Project Name: Bishop Street Apartments
Application ID #: #2015-060
Project Location: 72 Bishop Street
Project Description: 30 Unit Housing Development
Funds intended for: Fee in Lieu of Street Trees (24)
Applicant's Name: Avesta 72 Bishop LLC
Applicant's Address: 307 Cumberland Avenue
Date of Form: 03-10-16
Planner: Nell Donaldson

Project Name: Bishop Street Apartments
Project ID: 2015-060
Address: 72 Bishop Street CBL: 293-C-002
Applicant: Avesta 72 Bishop, LLC
Planner: Nell Donaldson

Bishop Street Apartments
72 Bishop Street
Level III Site Plan and Subdivision Review
2015-060
Avesta 72 Bishop Street, LP

Submitted to: Portland Planning Board
Date: July 10, 2015
Public Hearing Date: July 14, 2015

Drawing file: 5. Final Approved Plans and Documents / L2_Site Layout.pdf

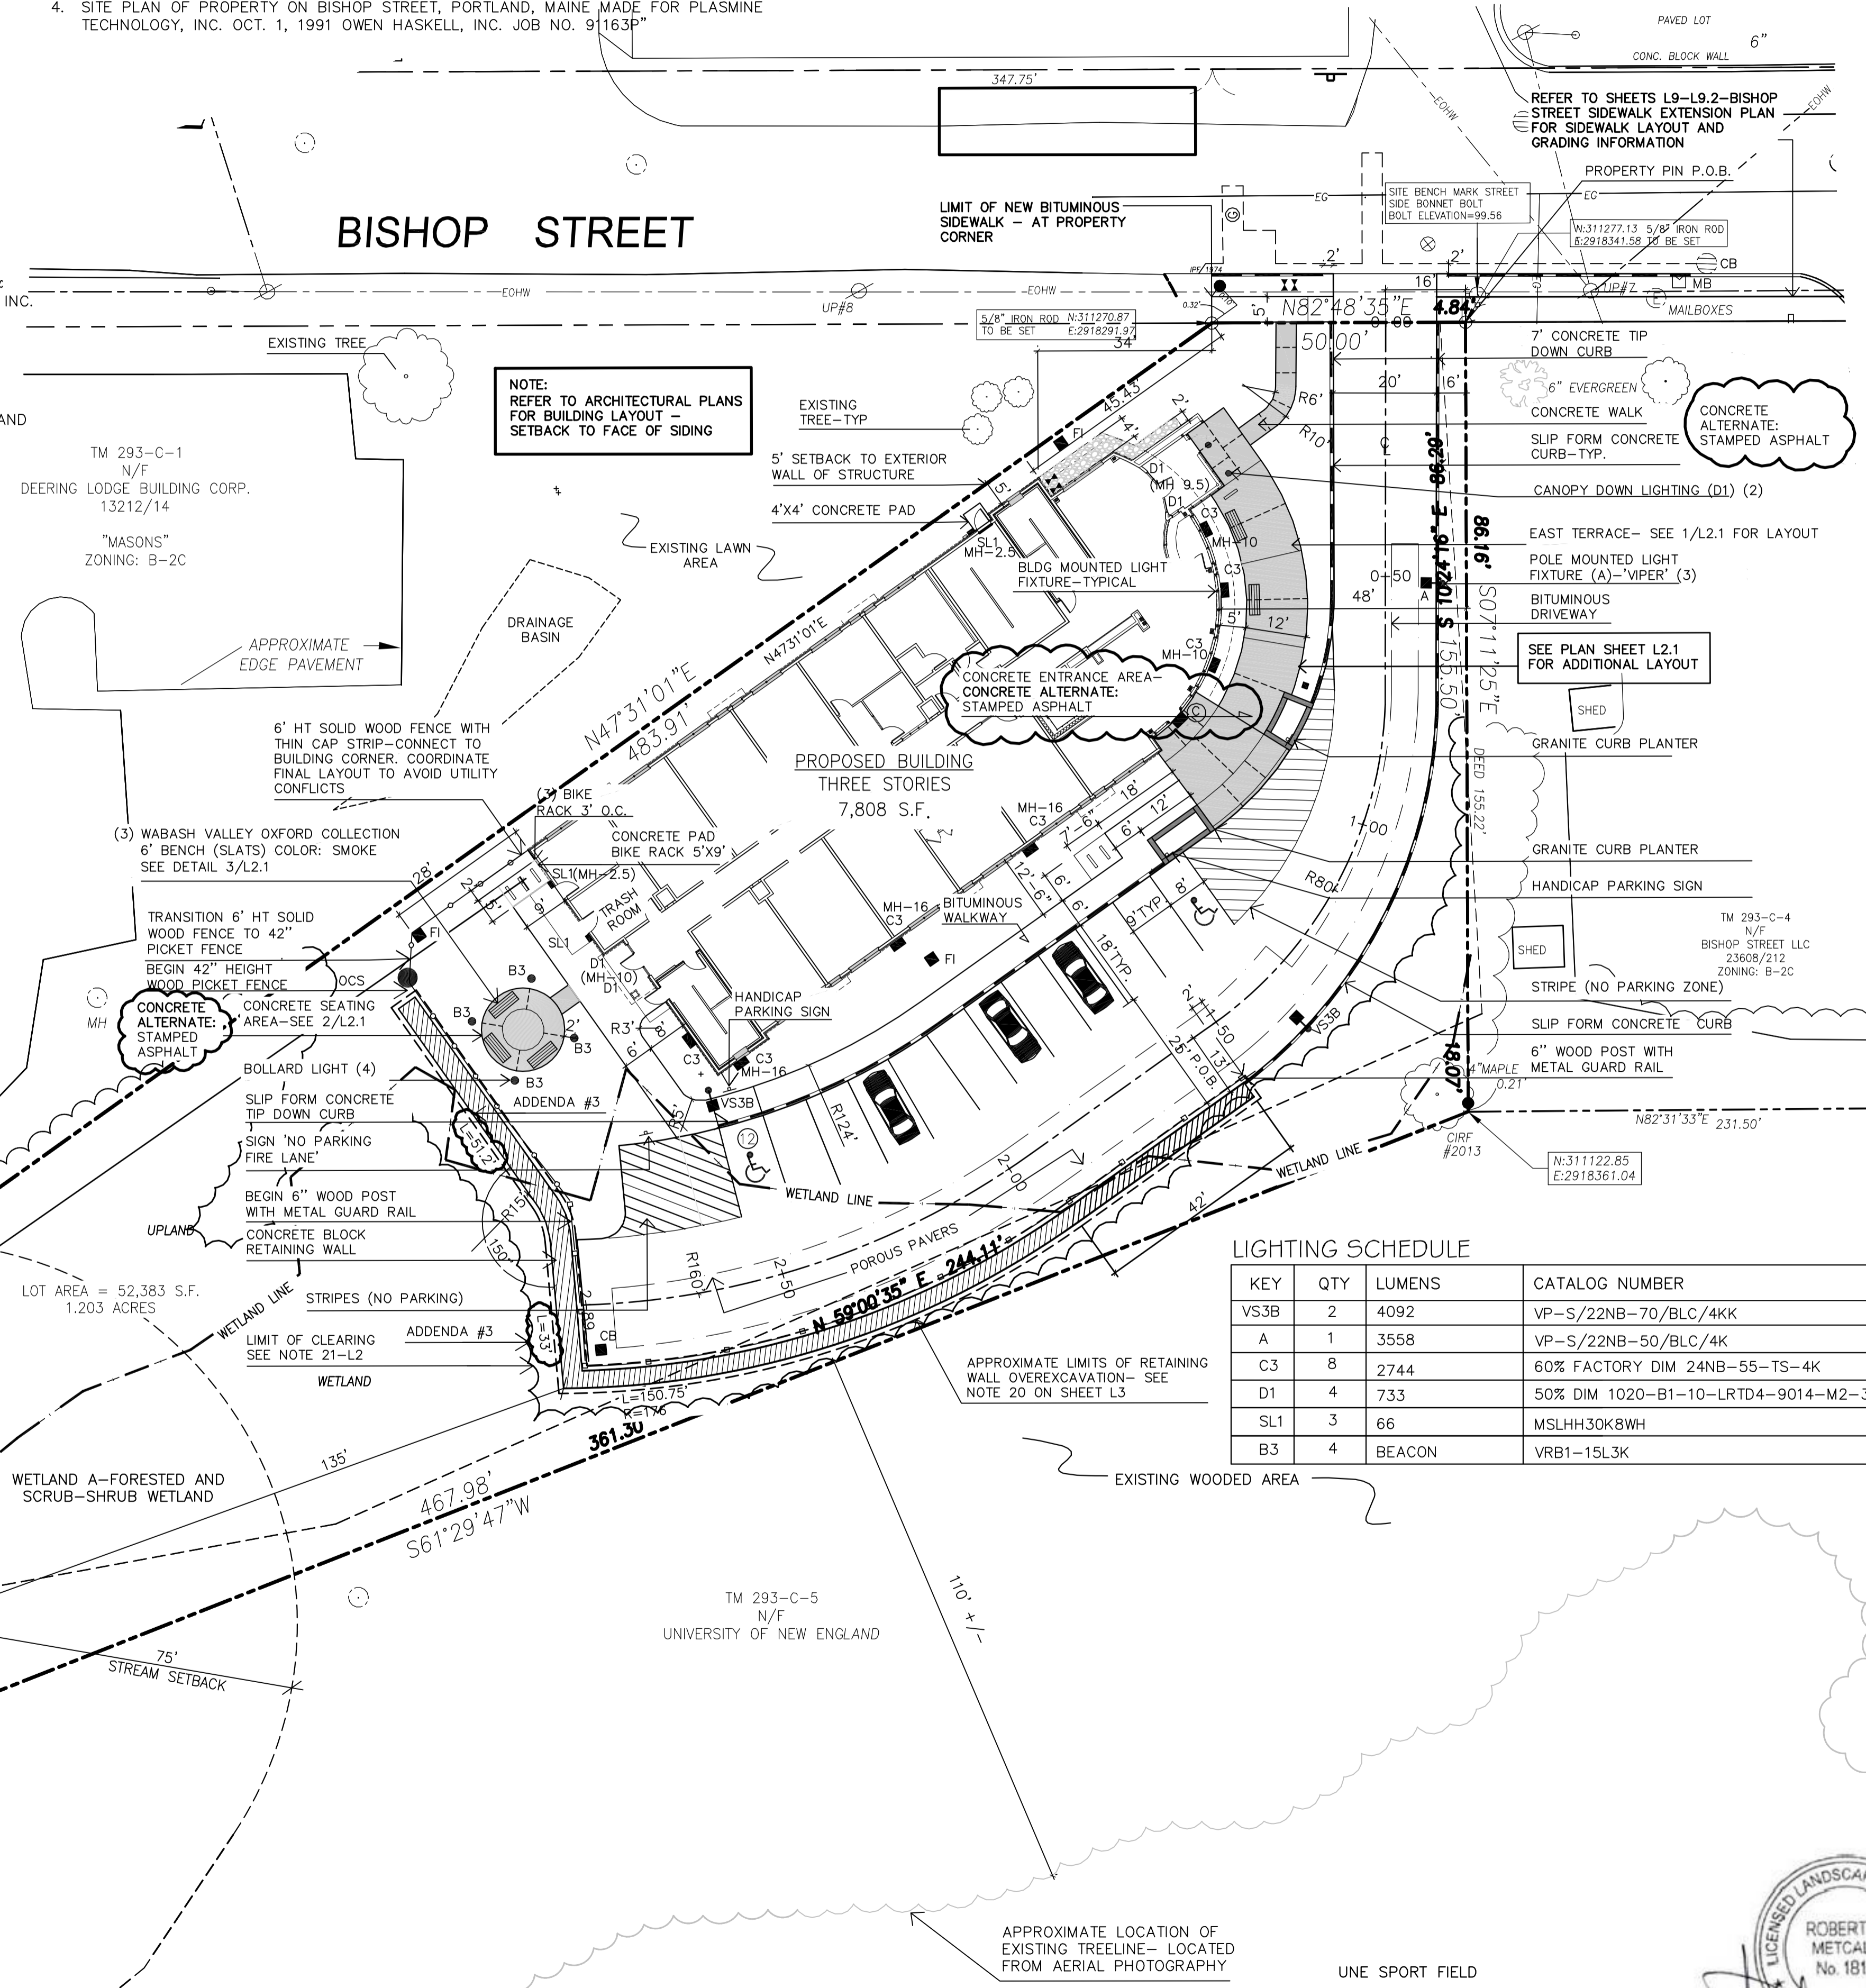
1. *Front Yard Maximum.* The B-2c zone establishes a front yard maximum of 10 feet, which the applicant continues to propose to exceed. At its closest point, the building is planned to sit 18 feet from the front property line (Figure 5). The ordinance does provide for an exception, stating that “the Planning Board or Planning Authority may approve a different amount for irregularly shaped lots or lots with frontage less than 40 feet provided this standard is met to the maximum extent practicable” (Section 14-185). The applicant has claimed in their site plan submittal that 72 Bishop is an irregularly shaped lot and that they have sited the building as close to the street as possible. The applicant writes,

“[t]he property is 50 feet wide at the property line and does not offer the ability to locate a 24 foot driveway and the primary building façade towards the street. Because of the low traffic volume entering the site and to allow the building to be as close to the road as possible, the driveway was designed as 20’ wide. The building is located as close as possible to the front property line (18’) to achieve the appearance of an active street front” (Attachment I).

Title: SUBDIVISION PLAT PLAN

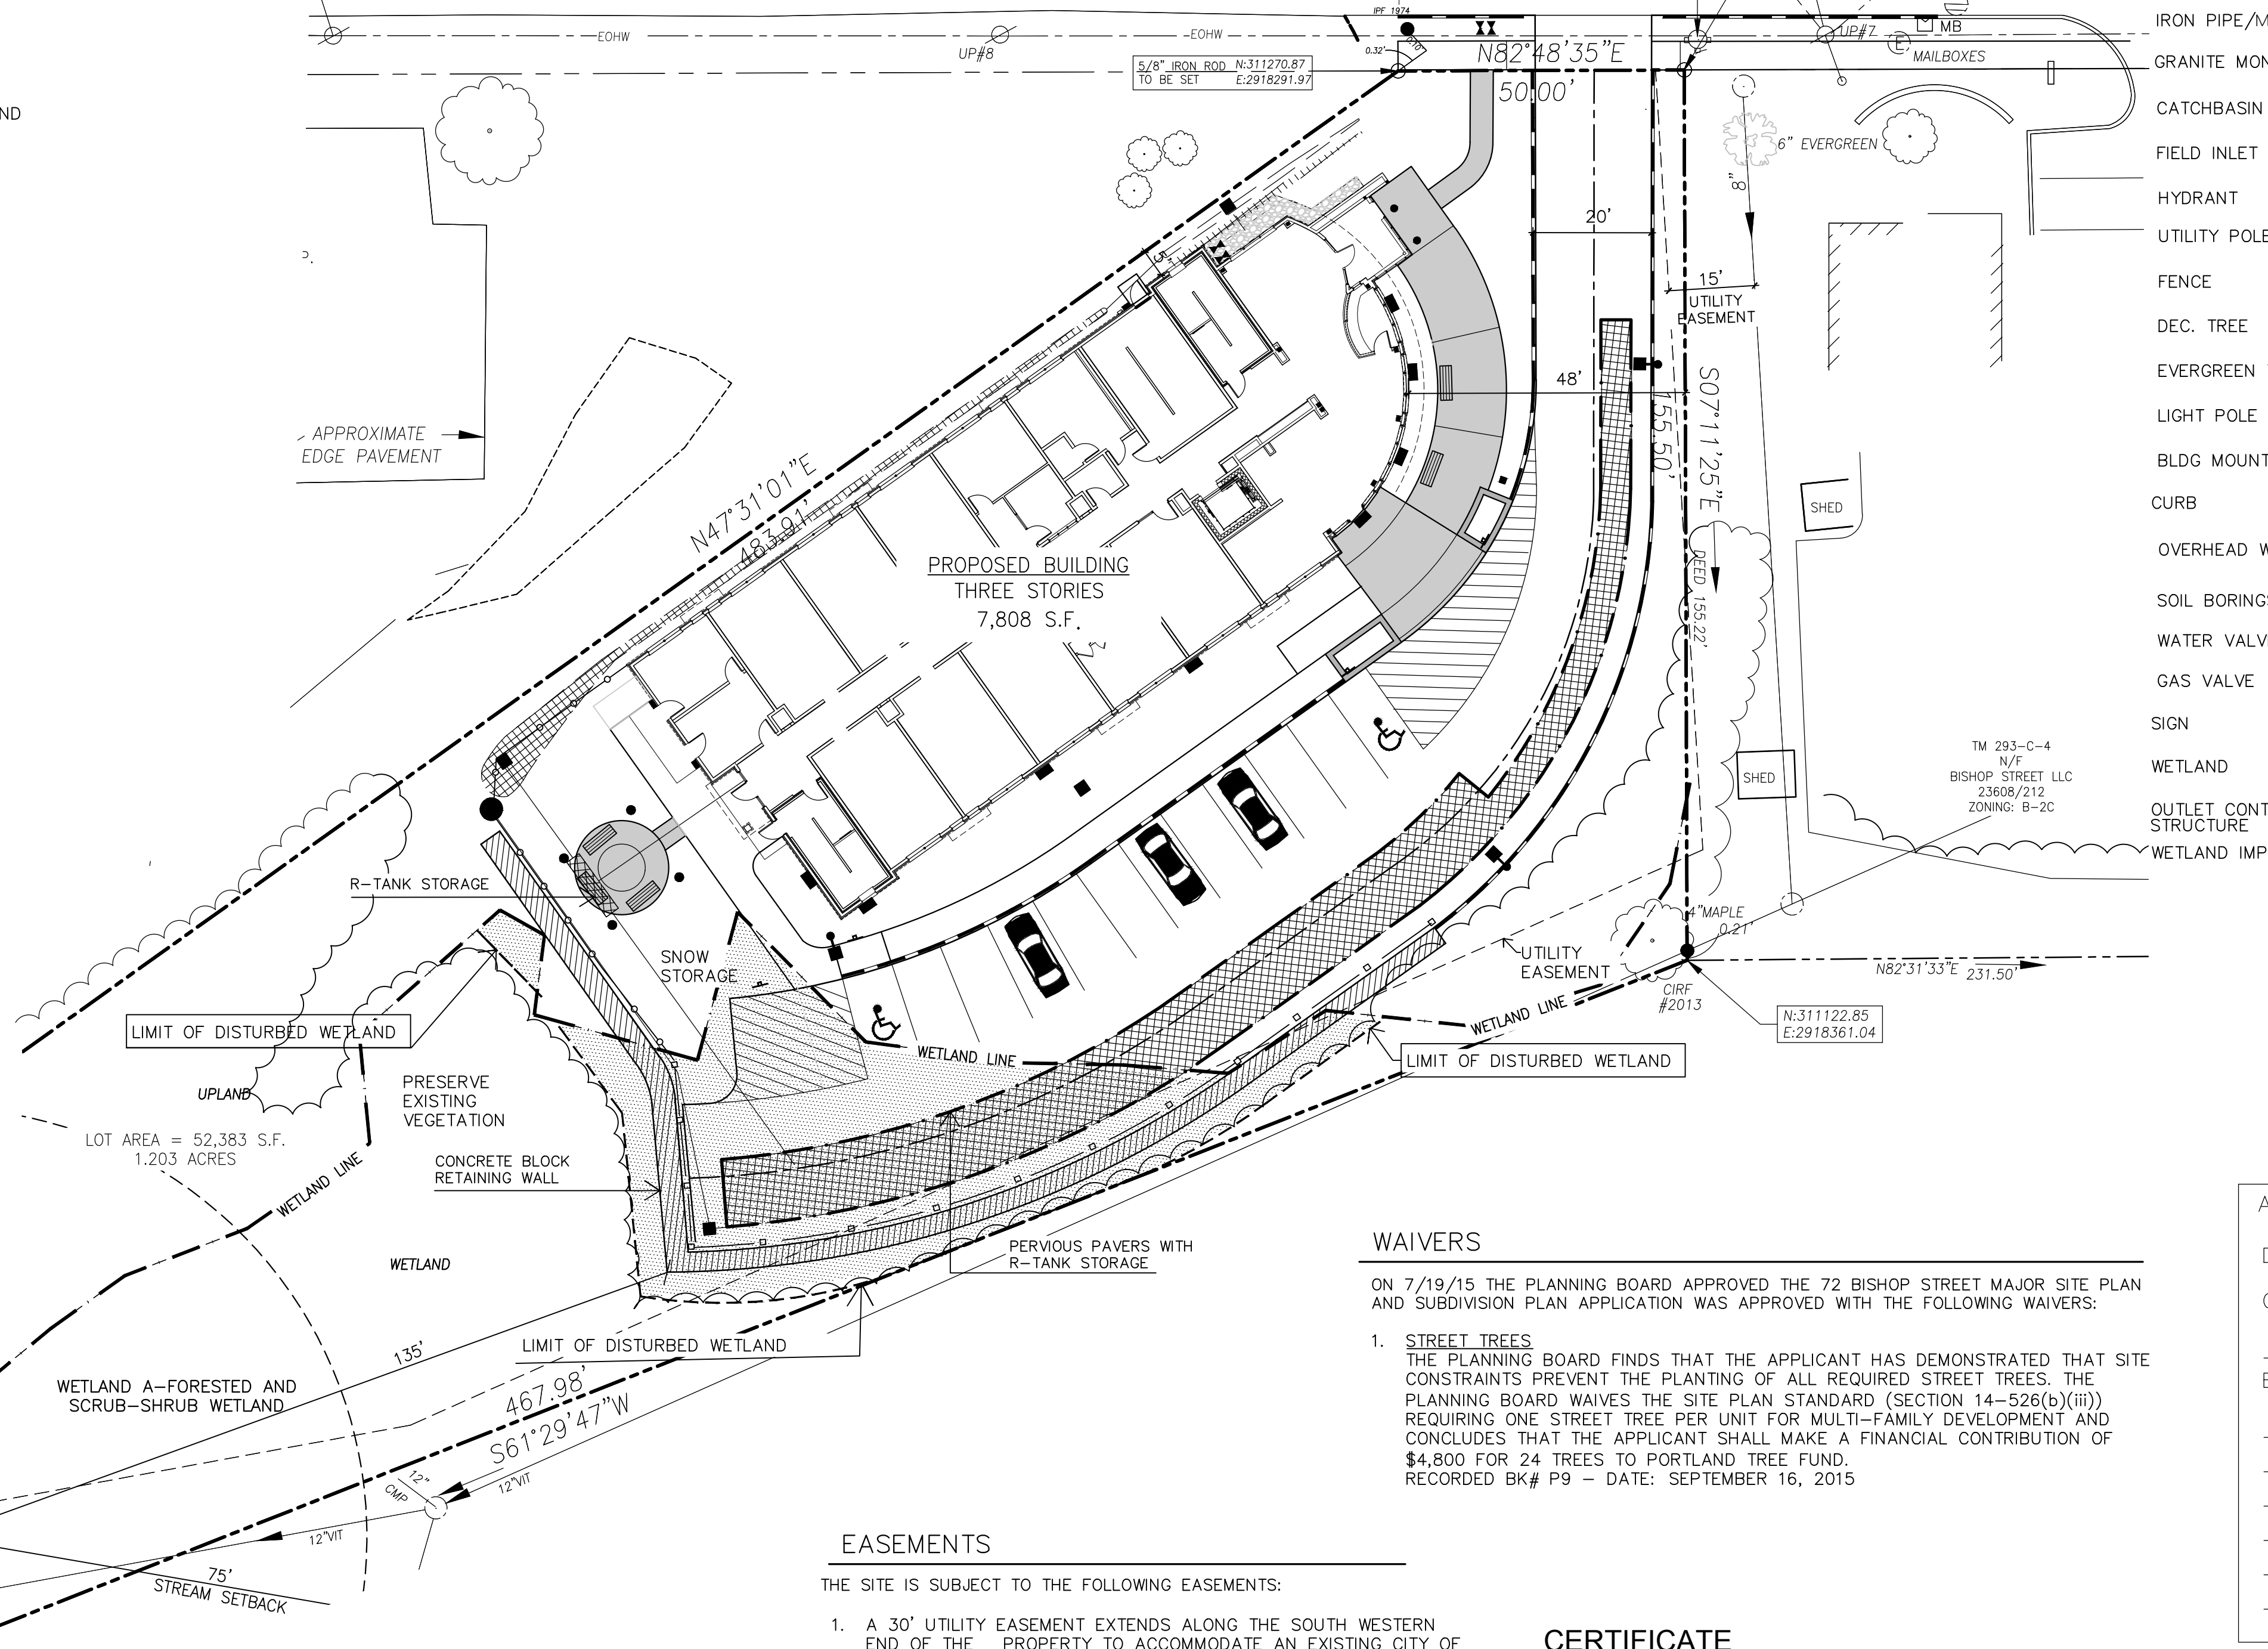
1. The applicant shall finalize the subdivision plat for review and approval by Corporation Counsel, the Department of Public Services, and the Planning Authority.

Mr. Clark, David Margolis-Pineo, of the city’s Department of Public Services, and Jen Thompson, Associate Corporation Counsel, have reviewed the draft subdivision plat and provided comments (*Attachments 2, 3, and 4*). The applicant has submitted a revised plat in an attempt to address these comments. Given additional changes which will be necessary following the planning board hearing, a final subdivision plat has been included as a condition of approval.
